**Bank Street Park Mod 2 (SSD-53386706-Mod-2)
 Response to Submissions**

This letter has been prepared by Architectus Australia Pty Ltd (Architectus) on behalf of Infrastructure NSW (INSW) in response to matters raised by the NSW Department of Planning Housing and Infrastructure (DPHI) in the letter dated 18 December 2026 for the proposed modification to Bank Street Park (SSD-53386706-Mod-2).

14 MARINA BUILDING - FLOOR PLAN.
1:50

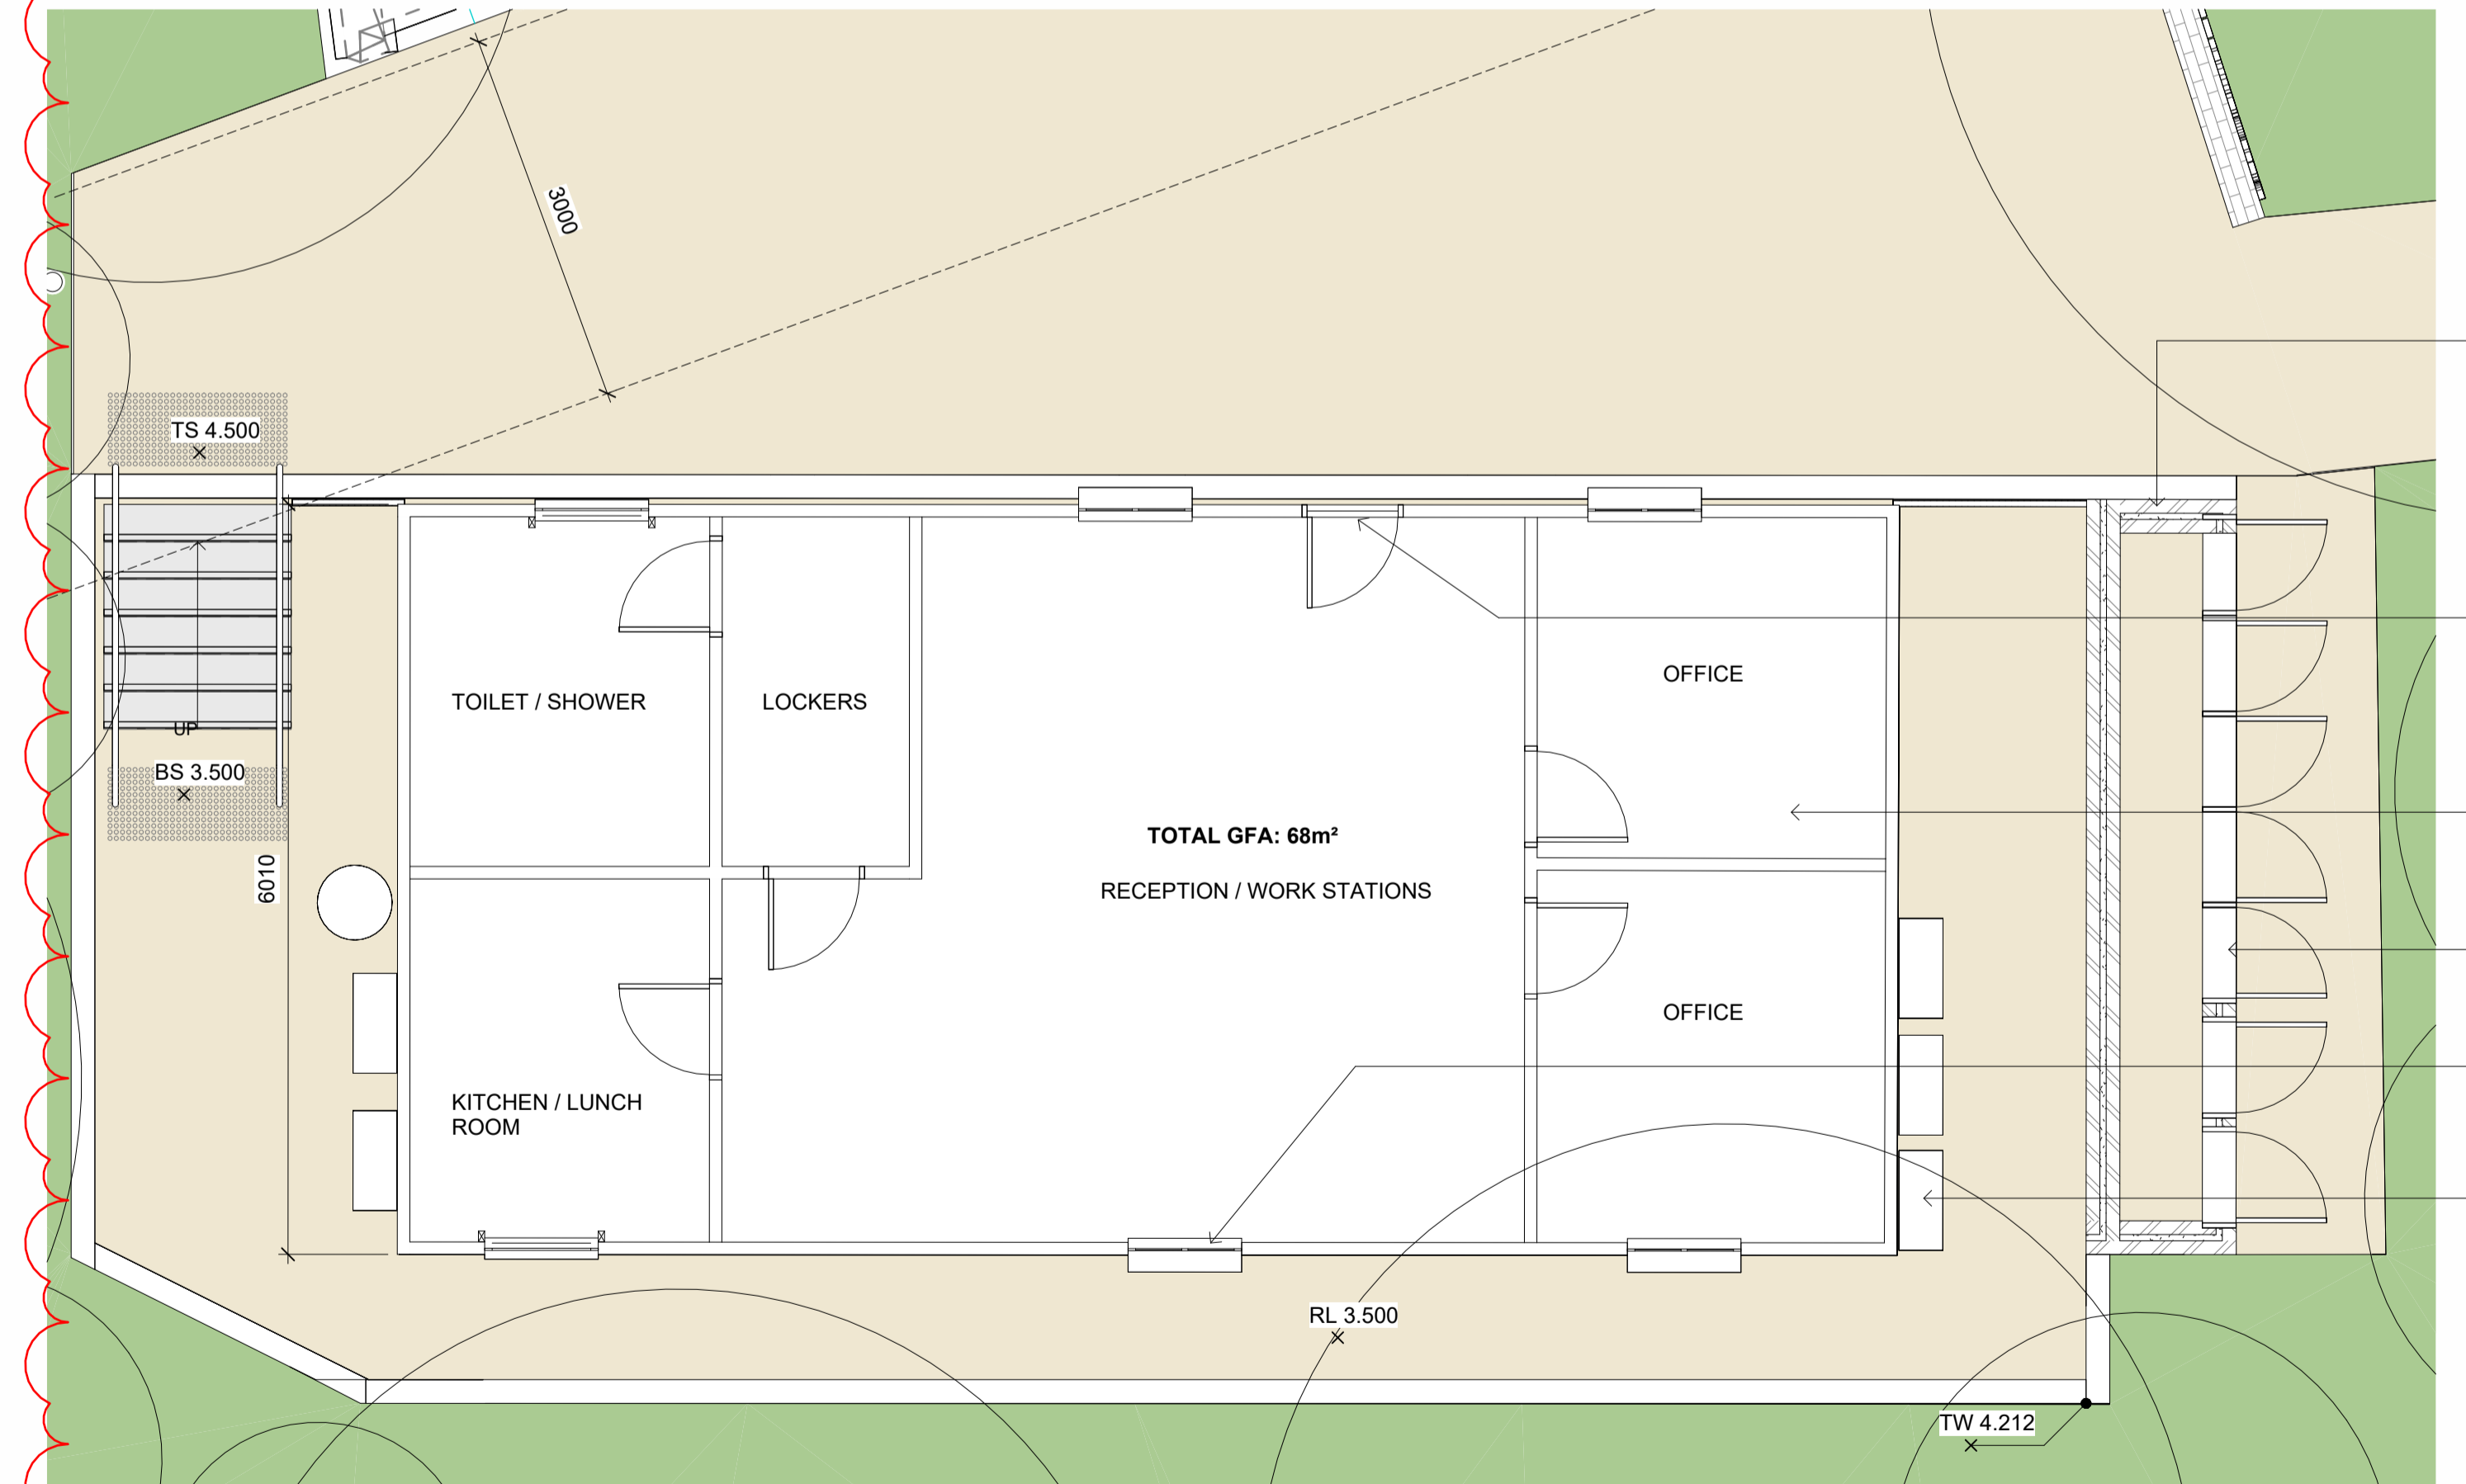
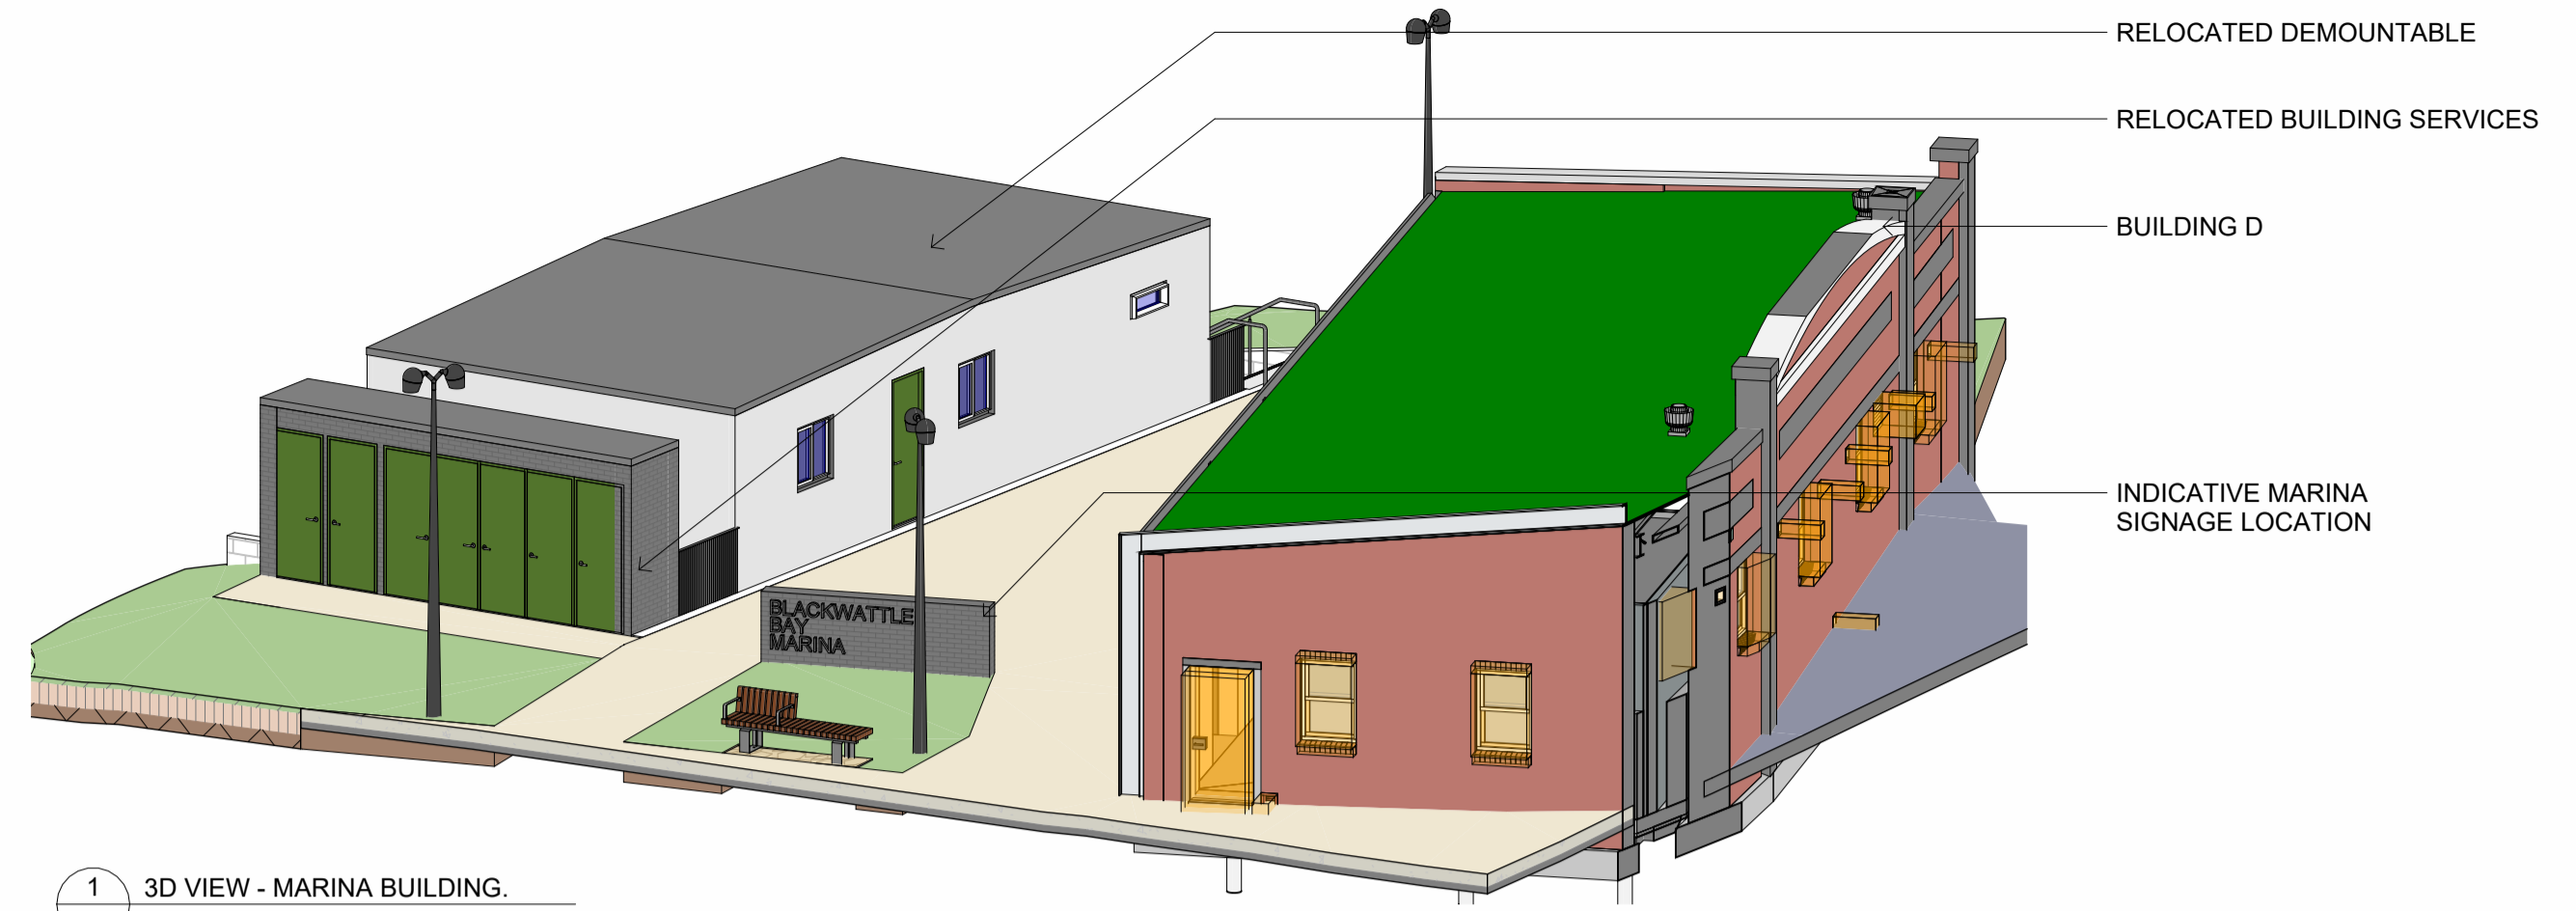
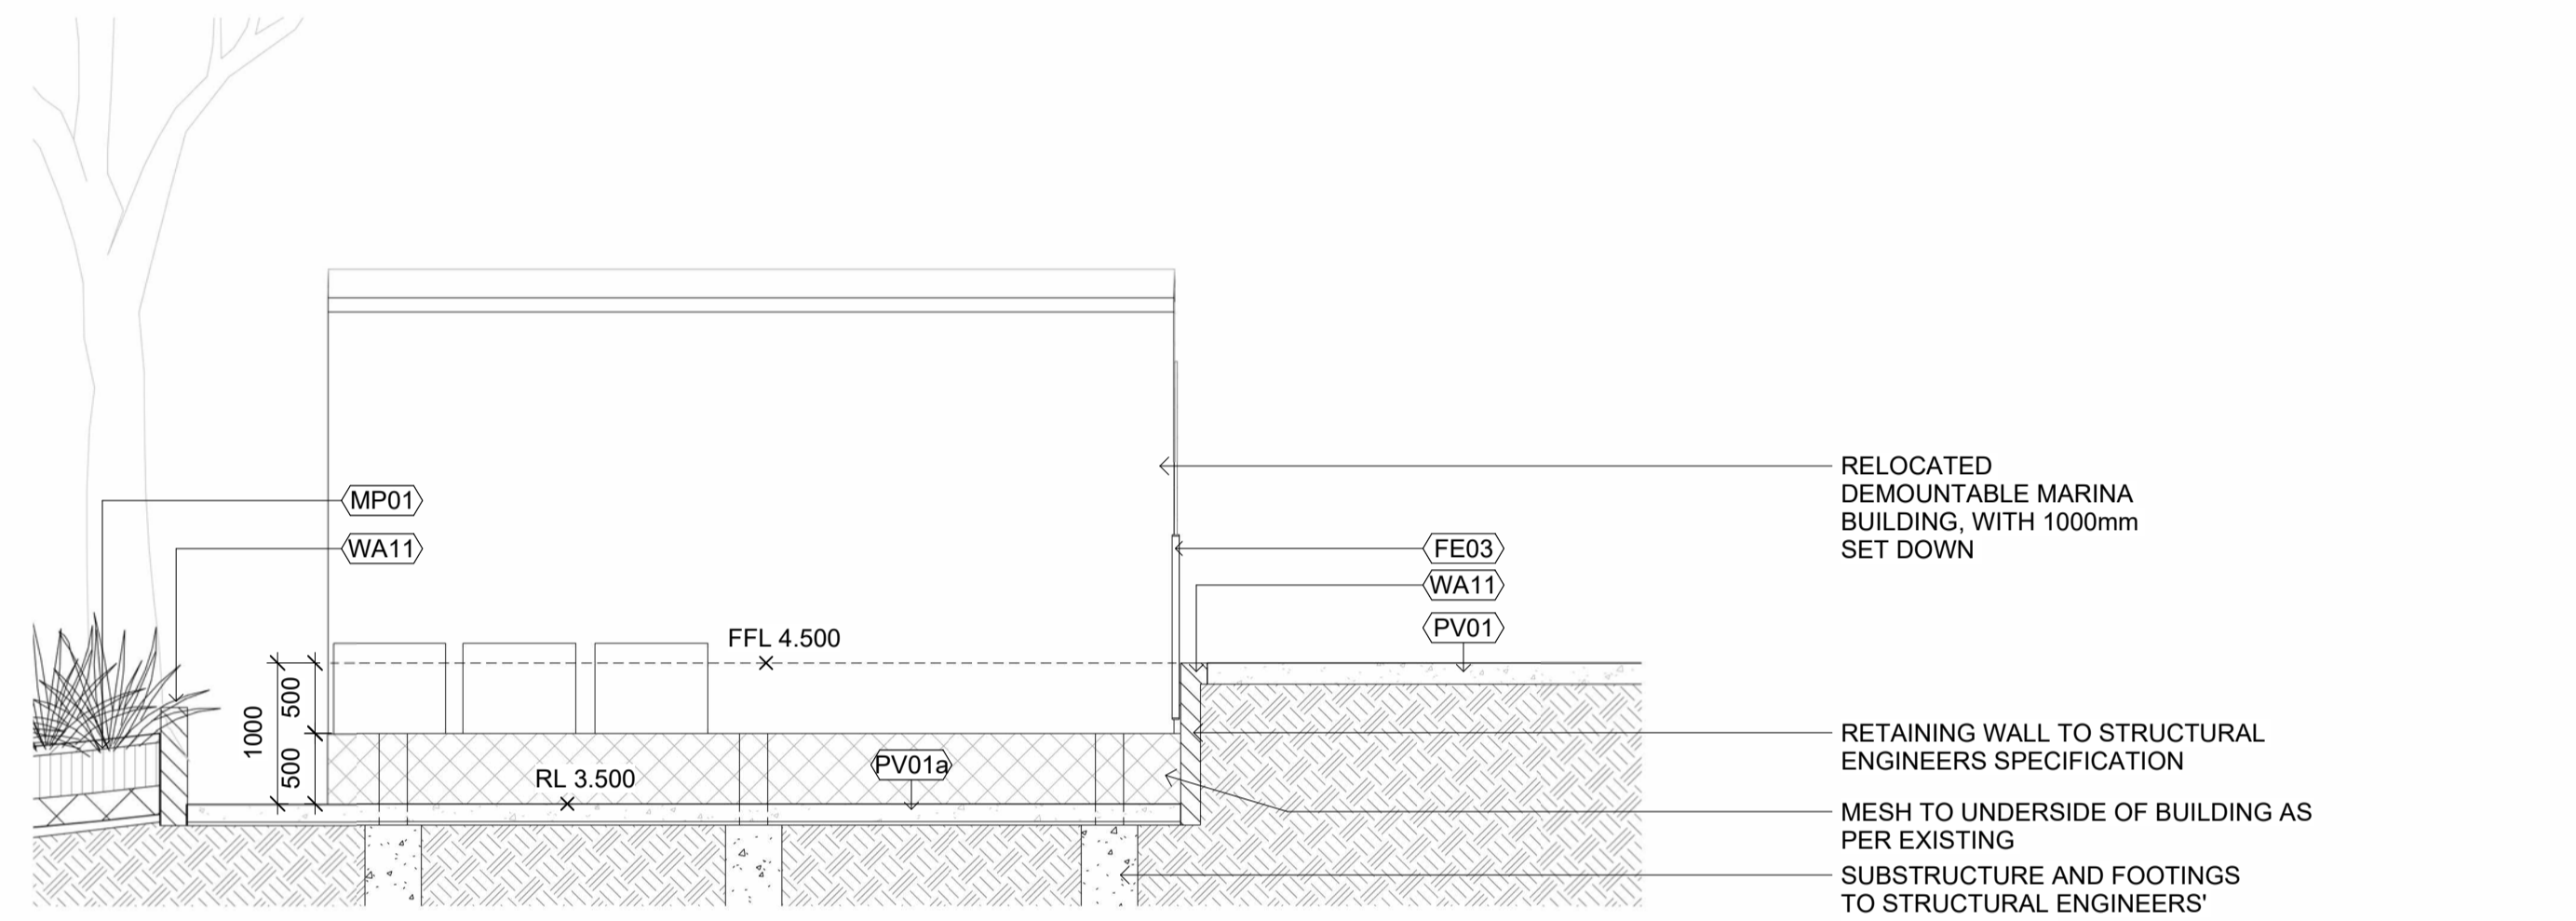
DPHI raised concern regarding fencing surrounding the new community building, including that this would unreasonably segregate marina functions and reduce integration given the open nature of the public park.

In response, fencing has been removed from the proposal as detailed in the marina building plans at **Attachment C**.
